Online Comment

Application	H02-0003-22
Location	WISTERIA BARN HEReward WAY CROWLAND PE6 0BL
Proposal	Erection of Dwelling

Name	Greg Watkinson
Address	Conservation Officer

Date Submitted	27-01-22
For/Against	Comments

Elevation 01 - Front
1 : 100

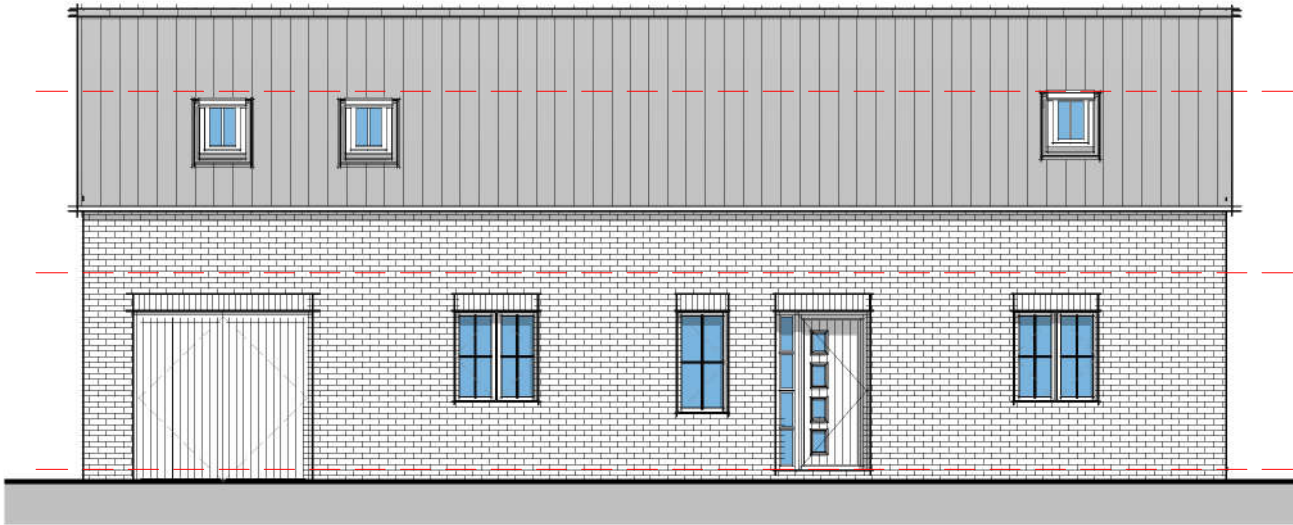
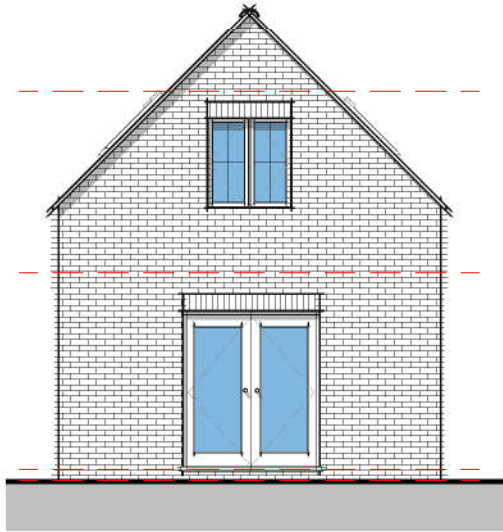
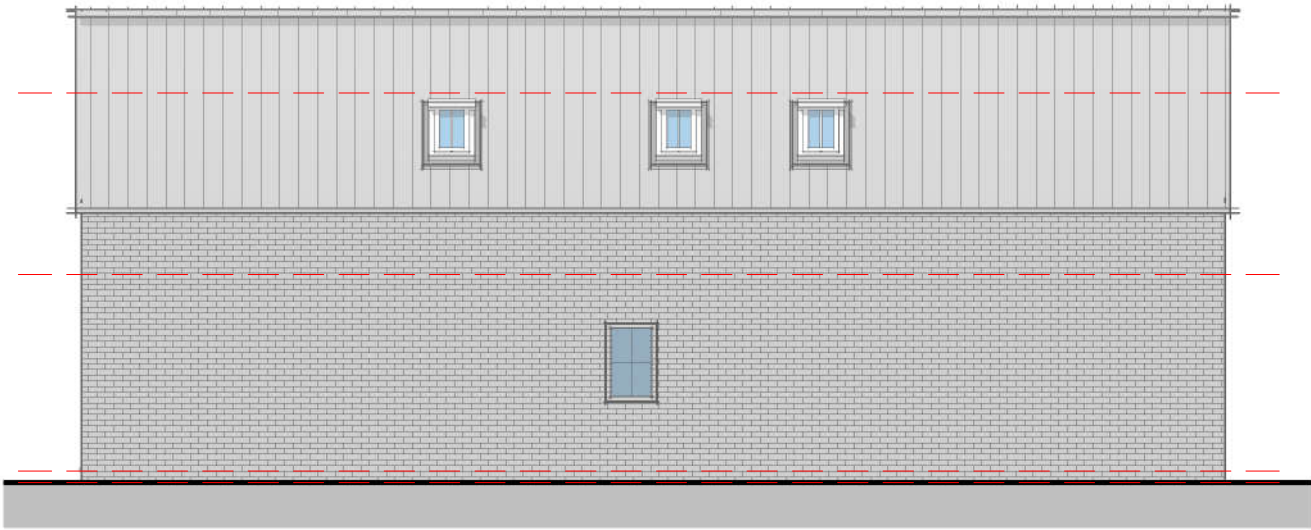
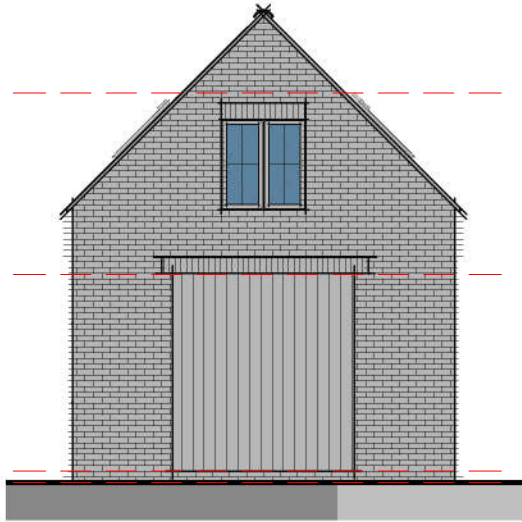
However, I note that the external materials including window, door, roofing, and rainwater good materials, are not included within the documents yet provided. Due to the conservation area setting, i would suggest that a full schedule of materials should be provided, either as a condition of an approval, or prior to the determination of this application. The applicant should be made aware that due to the conservation area setting, there will be an expectation that materials should be of high quality and sympathetic to the setting (e.g. timber windows and doors, clay pantile roof e.t.c in reference to Wisteria Barn).
